HILLPOINTE APARTMENTS AT PETERSON
CONSTRUCTION DRAWINGS - STORM SEWER PLAN & PROFILES

HILLPOINTE APARTMENTS AT PETERSON
HILLPOINTE, LLC.
COLORADO SPRINGS, EL PASO COUNTY, COLORADO

CONSTRUCTION DRAWINGS
STORM COVER & NOTES

TYPICAL SECTION –
MAINTENANCE ROAD

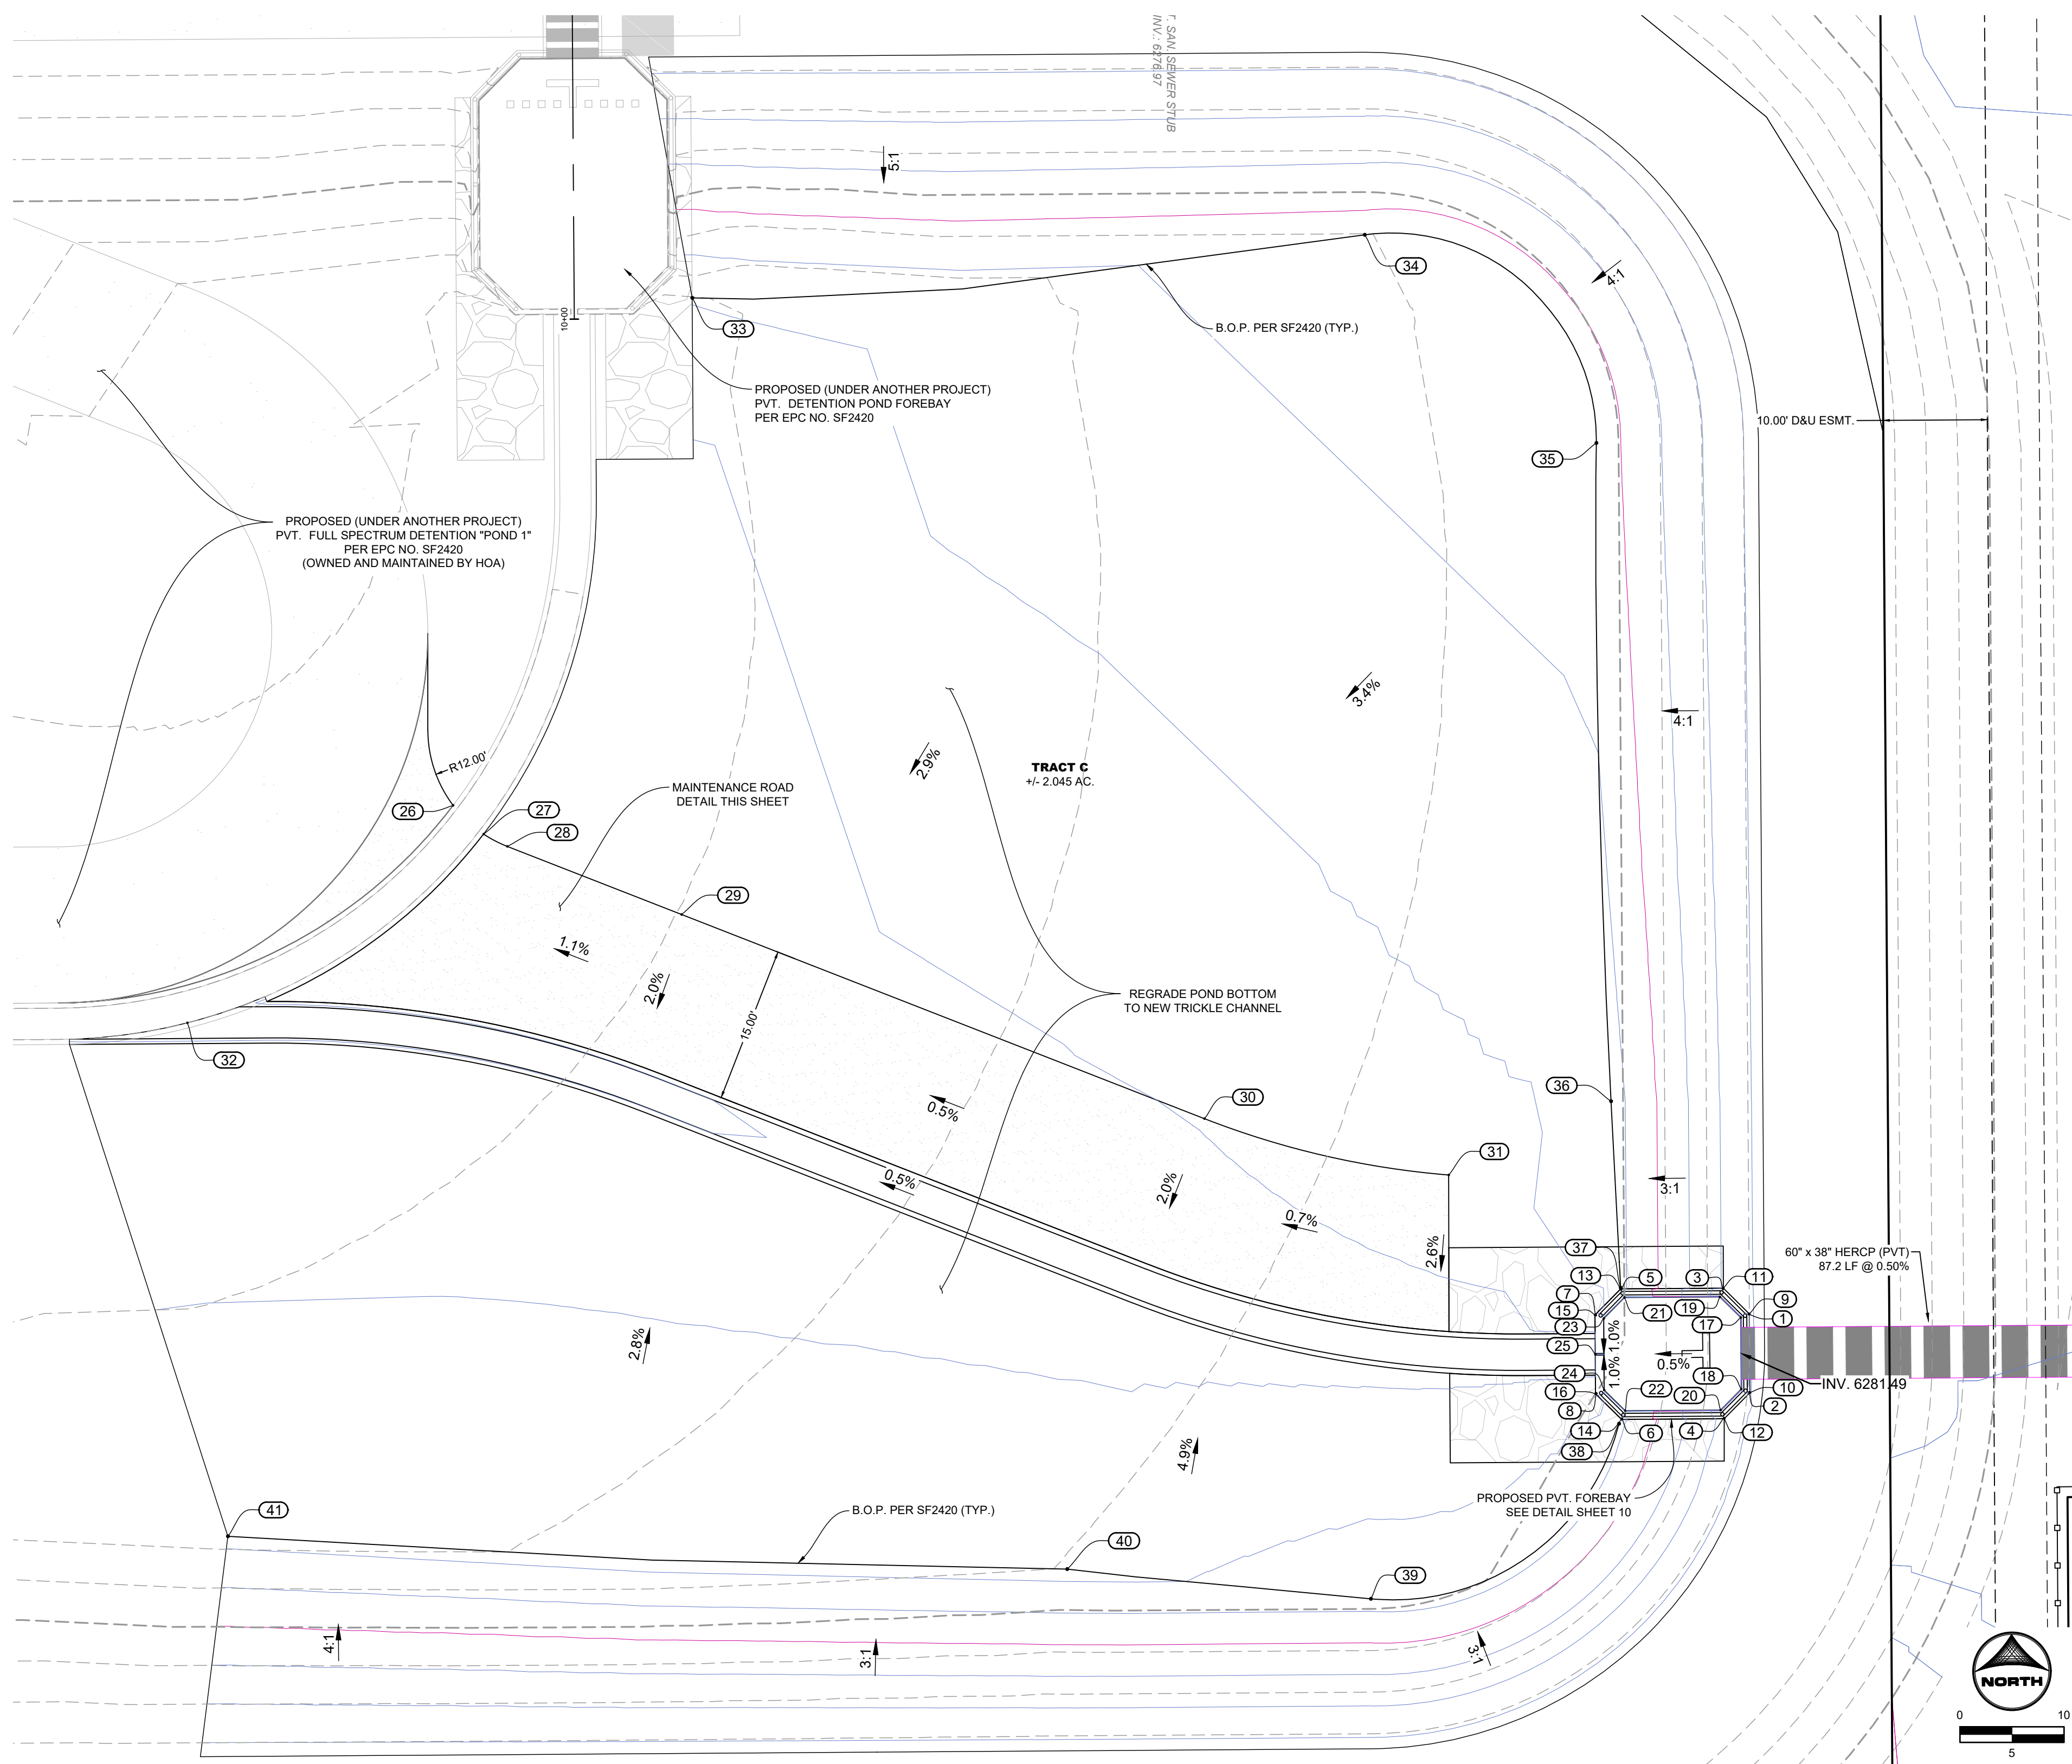
Please add forebay, trickle channel, and maintenance access road designs from SDP to CDs for engineering approvals.
